DEPARTMENT OF PLANNING AND DEVELOPMENT

RE: Waiver Request 19 North St. (014 A022 Permit#021187)
Dear DiDonato

This office has reviewed your request dated 11/25/02, with regard to the fire separation distance for the raising of the roof line on the existing 2nd floor at the above location.

NORTH ELEV.

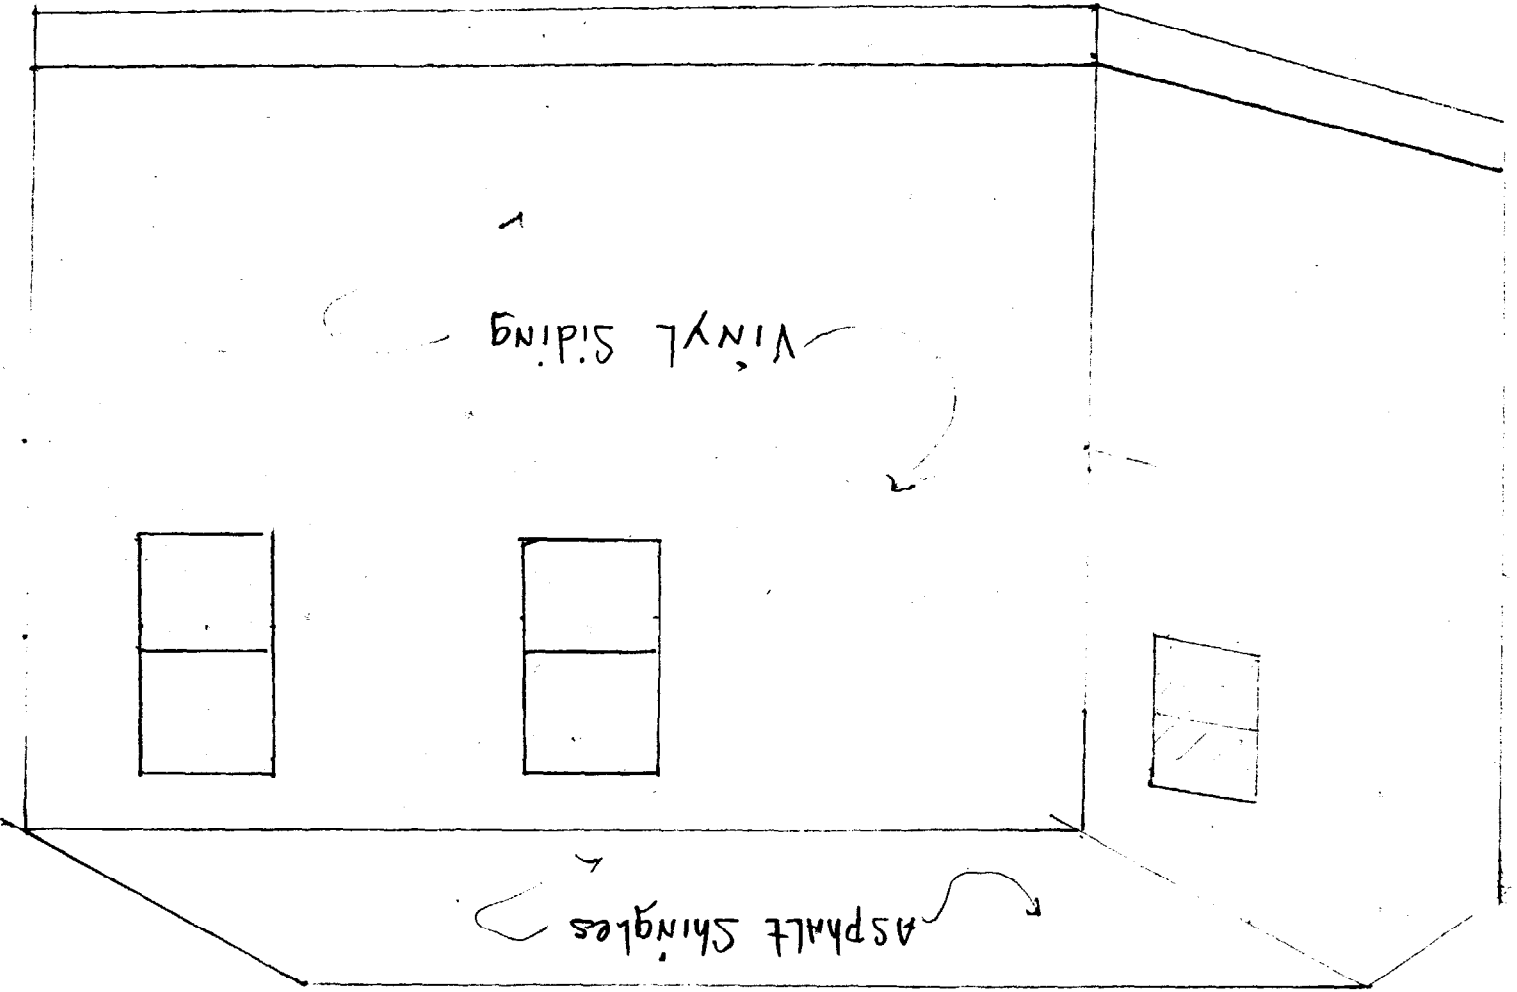
- 1) The existing two family home is 1'8" from the left side lot line, Section 14-436A of the Zoning Ordinance allows a 50% vertical expansion.
- 2) The parcel is located in the R6 Zone.
- 3) The sideyard setback is 10 feet.
- 4) The structure on the adjacent parcel is 26 feet from the subject structure.
- 5) The proposed structure is an R3 use group, Type 5B construction. All modifications will be Type 5B construction.

The applicant proposes that the City measure the fire separation distance to a line that is one half the distance from the subject structure to the structure on the abutting property, much like the code requires for development of multiple buildings on the same lot. This distance is 5 feet 8 inches.

- 1) The inside face of the exterior wall shall be covered with type "x" 5/8 inch gysum board.
- 2) The unprotected openings shall be limited to 10% of the wall surface.
